From: [REDACTED]
Sent: 22 August 2025 10:37
To: 'Andrew Rockett'
Subject: Wroxton second draft

We write in relation to the works undertaken to stabilise the independent barn adjacent to the North Arms, Wroxton, with particular focus on the two comments from Cherwell District Council;

6 3D view Steel work only

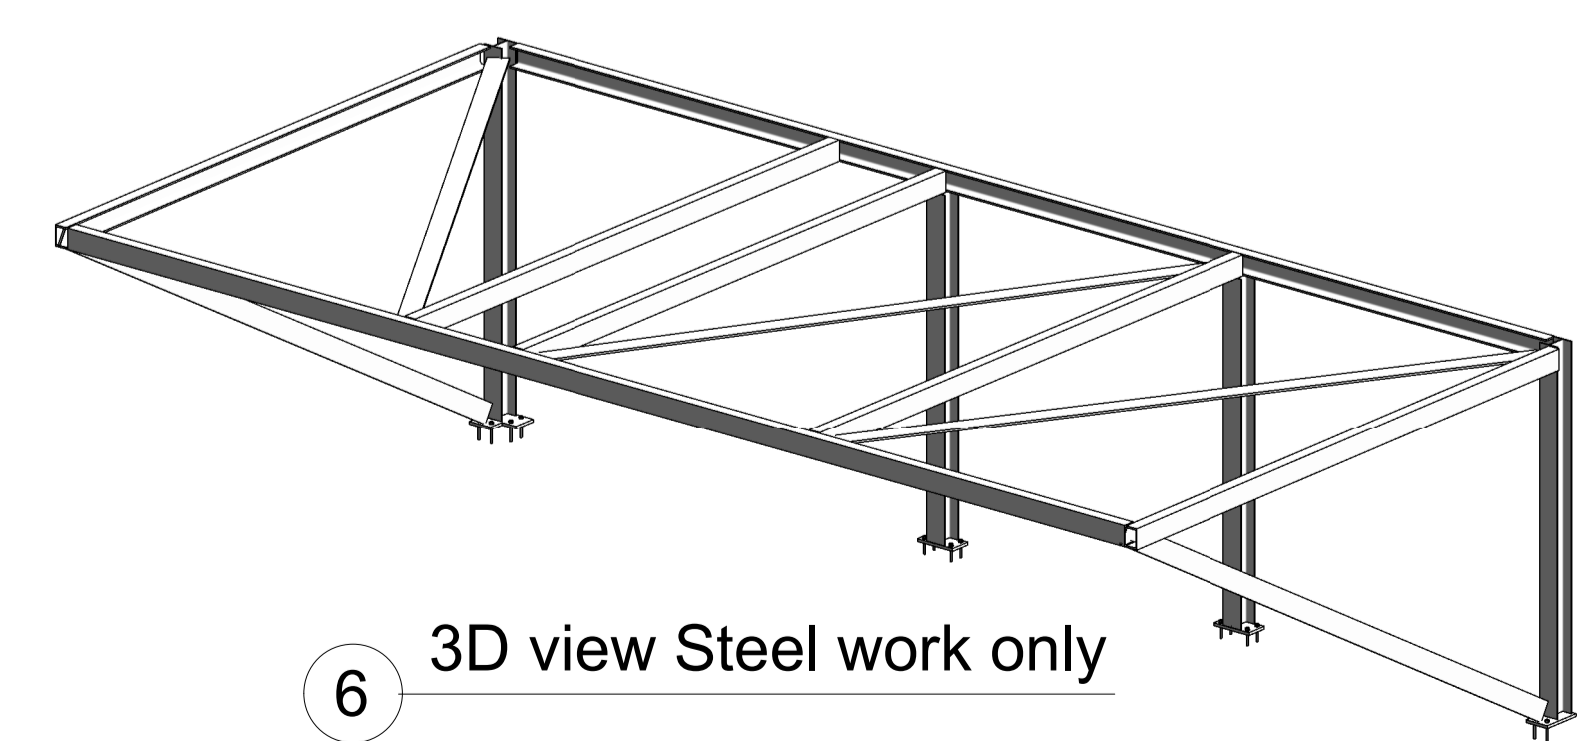
Clarification is needed on the works undertaken; what work has been done, how is internal wall attached ; full methodology and justification

Justification should be provided for cutting of the existing beam to install steel framing ; justification and specification of steel frame is needed

In order to retain as much of the original historic walls as possible it was decided to cast a new concrete support wall in front of the original stone wall and to leave the stone wall in place. It was necessary for the concrete wall to provide lateral overturning resistance and if this were to be achieved with a concrete base in a traditional “L” shaped wall, extensive excavation would have been necessary at the base of the wall, which in itself would have been destabilising. It was therefore proposed to erect a steel grillage frame which would be

braced back to the side walls rather like a series of buttresses to allow the concrete to be cast in panels, which were then themselves supported by the frame. This work only involved localised excavation next to the base of the wall to form footings for the steel posts.
